**Campus Park East (Bellway Homes)**  
**Application Reference: /6/2022/2801/MAJ**

**Comments & Objections from Cllr Russ Platt (Ward Member, Peartree)**

Parking

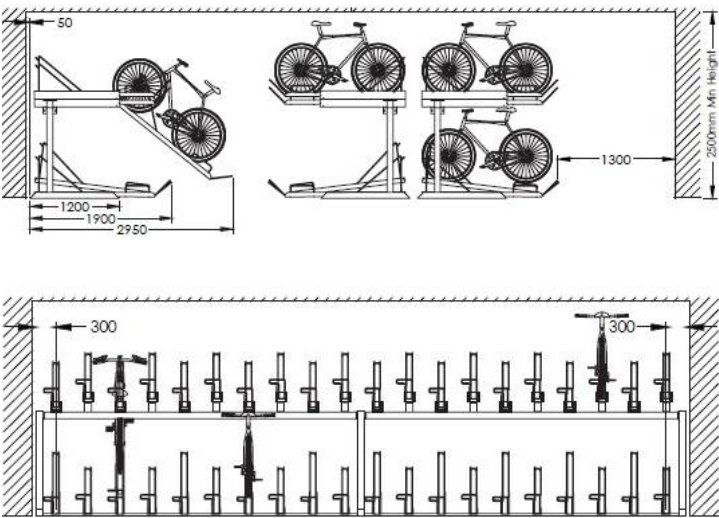
8. **Parking Rate.** The allocation of parking on the application is 0.58 per dwelling overall. Whilst this is a town centre site and can be deemed to be more sustainable than elsewhere, real and current evidence from the 2021 census shows that car ownership in the immediate area (Handside and Sherrards), is significantly higher. In fact, it shows clearly that at least 77% of

9. **Parking Split.** While the owned homes will all have a parking space, the 'affordable' homes will only have 0.37 per home. This is clearly insufficient and there is no justification, rationale or supporting evidence for the assumption that those living in affordable homes have less requirement for a vehicle.

10. **EV Charging.** The allocation of spaces equipped with EV is at 50%, this is in contravention of building regulations Part S introduced in 2021. Whilst officers may state that this is a building regulation rather than planning regulation, it would be wholly negligent and remiss of any officer to recommend an application for approval, whilst being aware that it contravenes building regulations.

Drawing file: 8375_P122B_Tenure Stacking Plan Lower.pdf

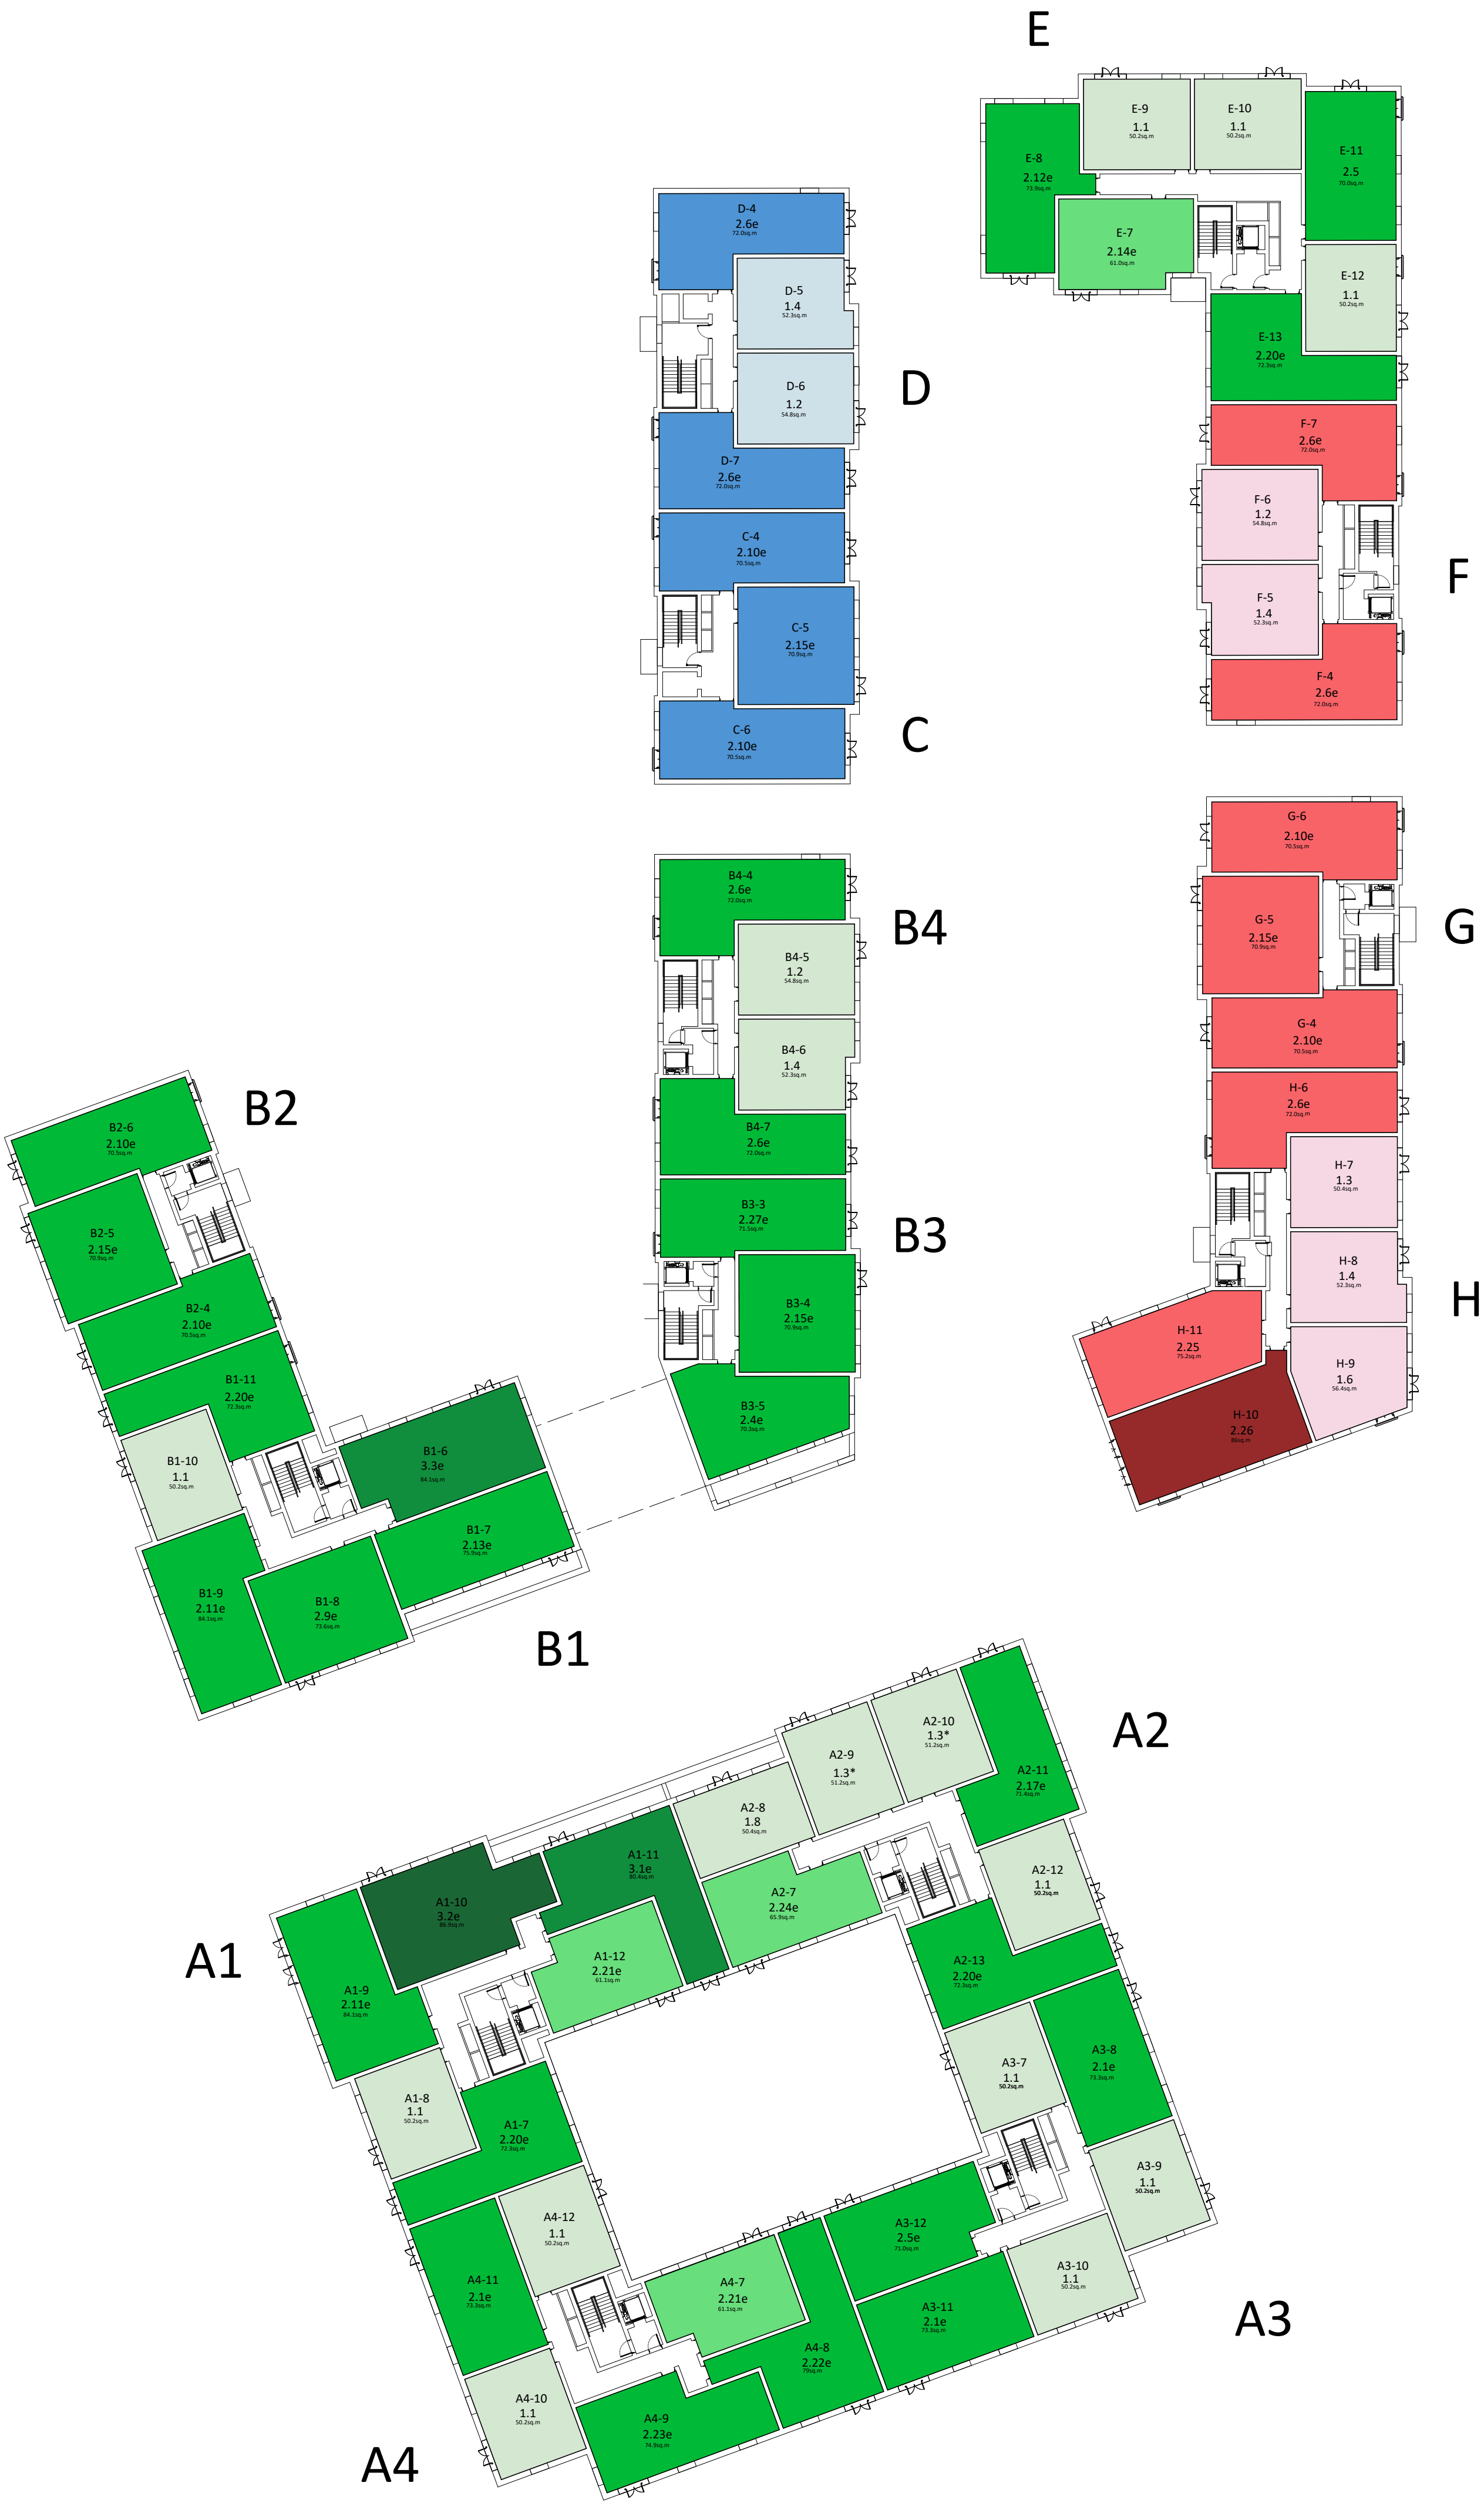
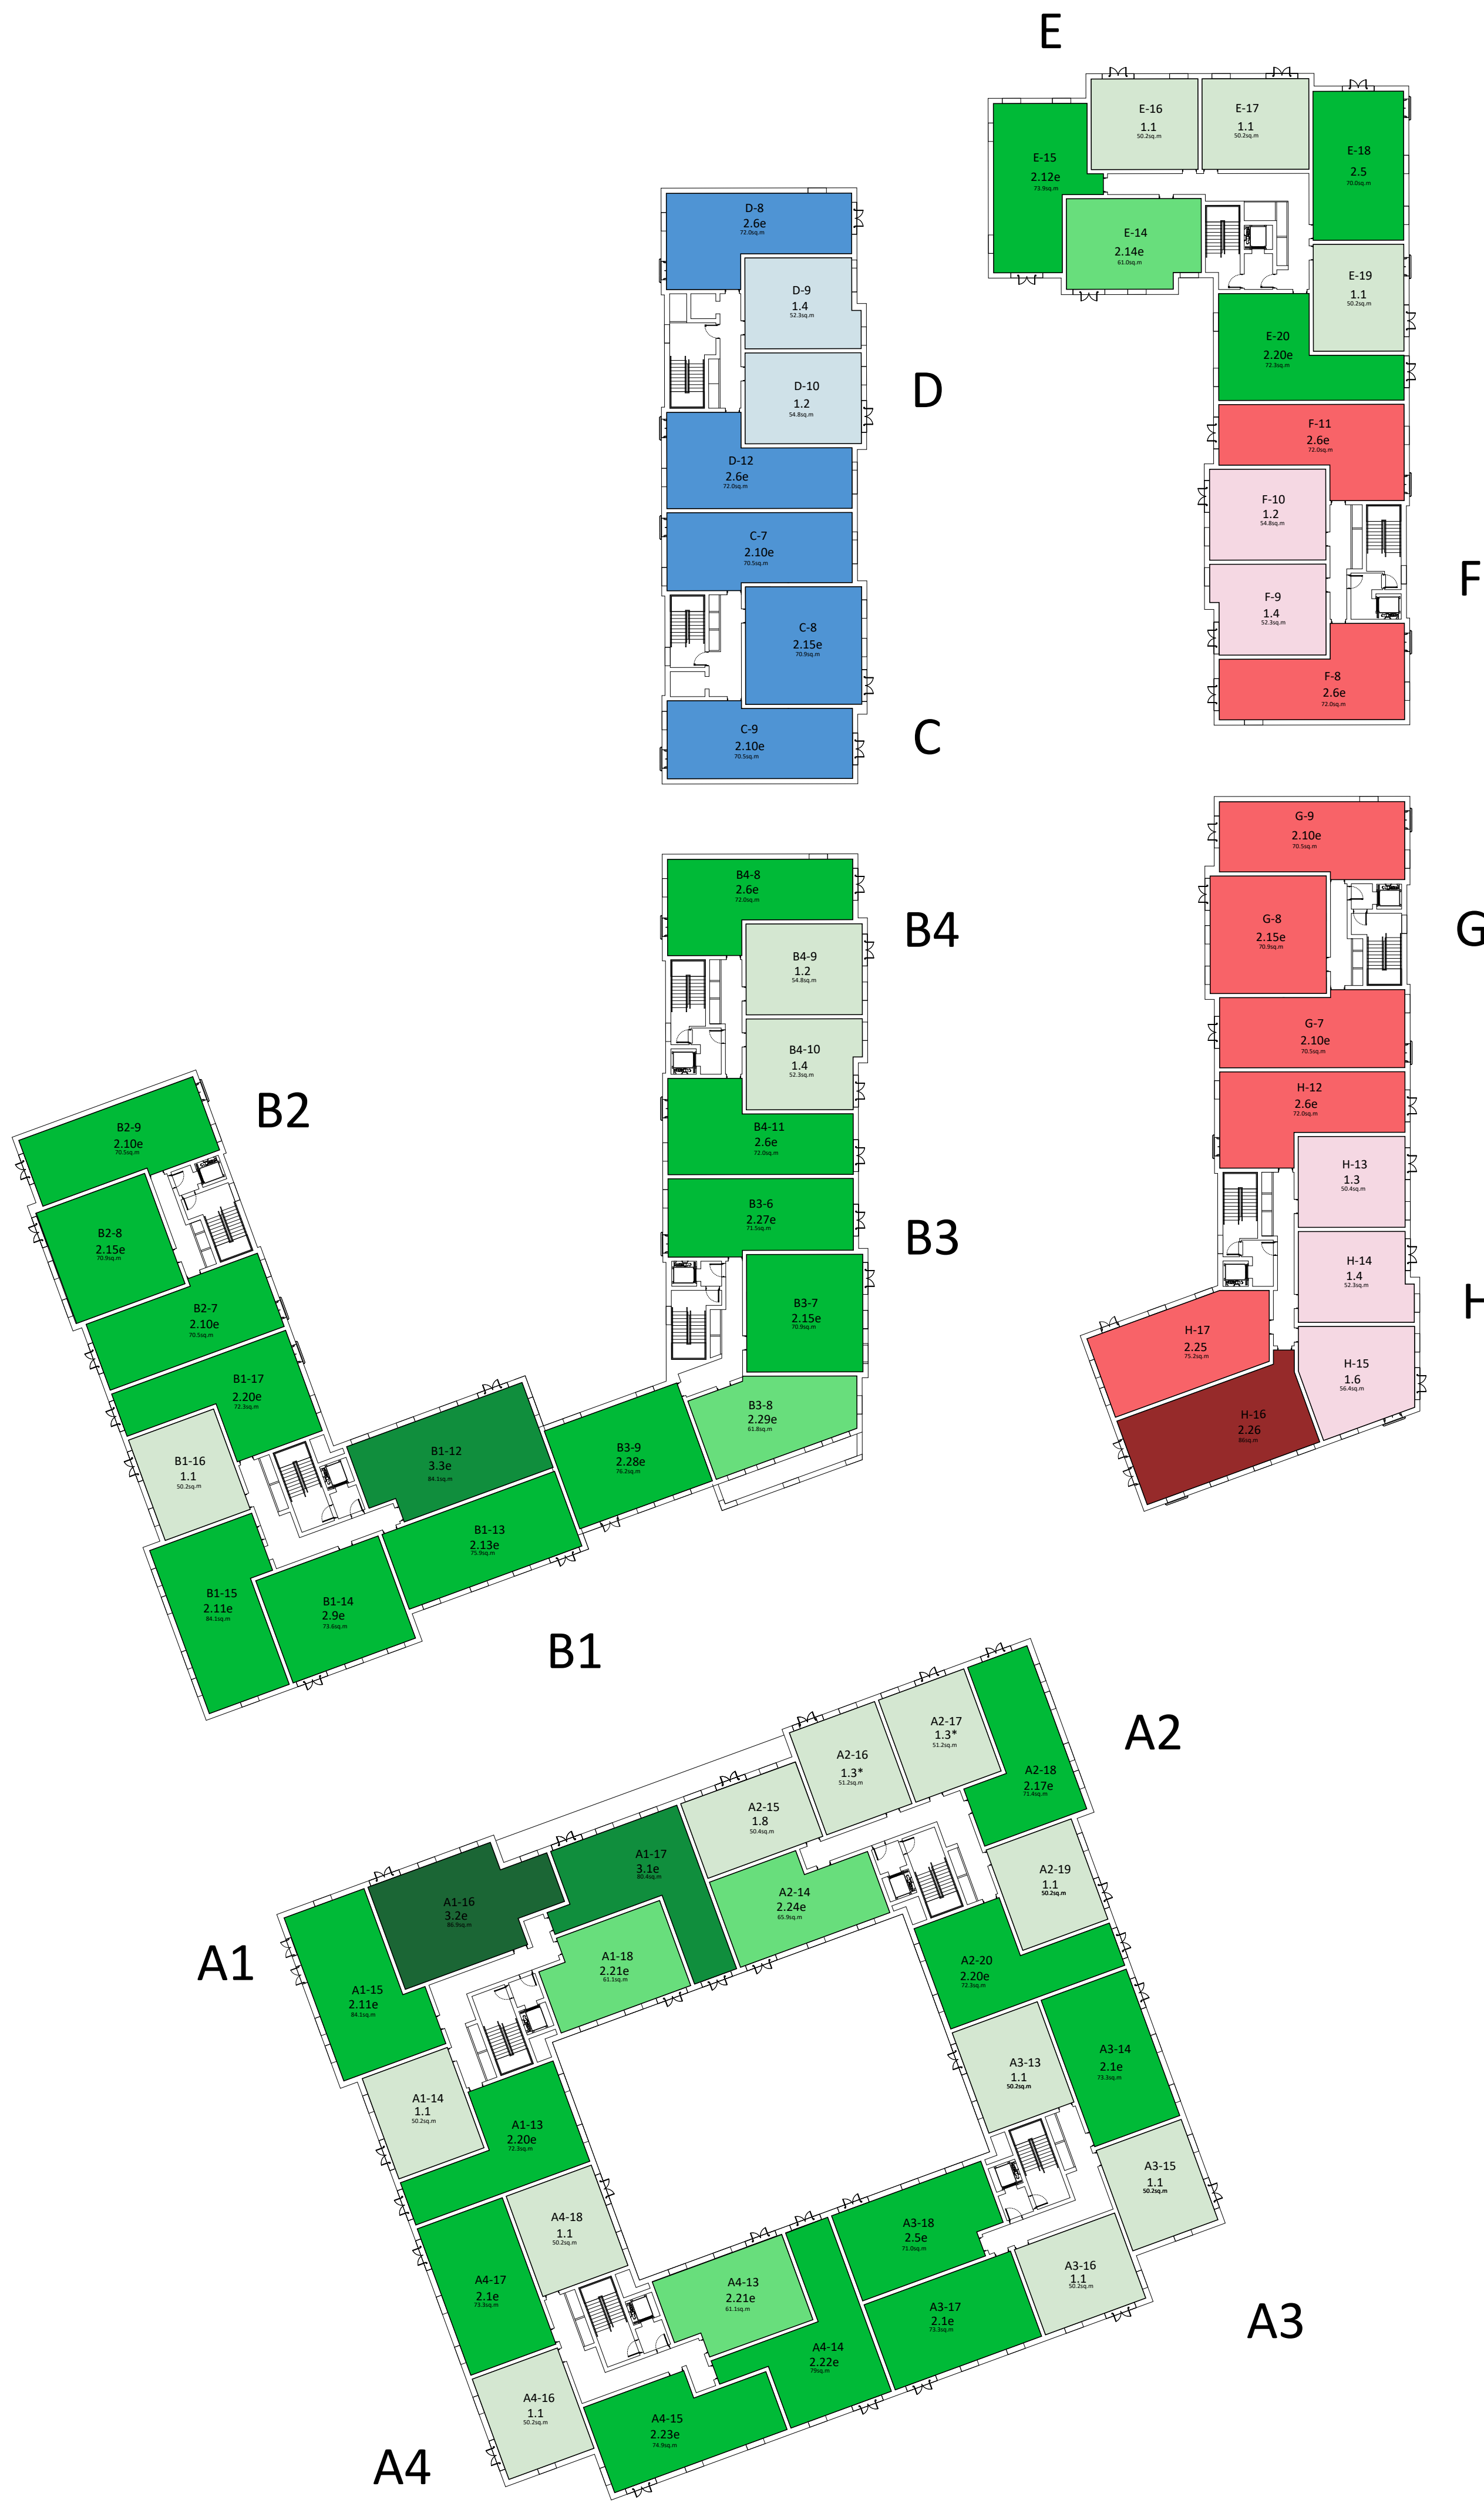
2. **Affordable Housing.** The current allocation of affordable housing is predominantly in one block. We have seen tangible evidence in local developments of this not working effectively. The affordable housing should be positioned around the development so as not to create a divide or stigma.
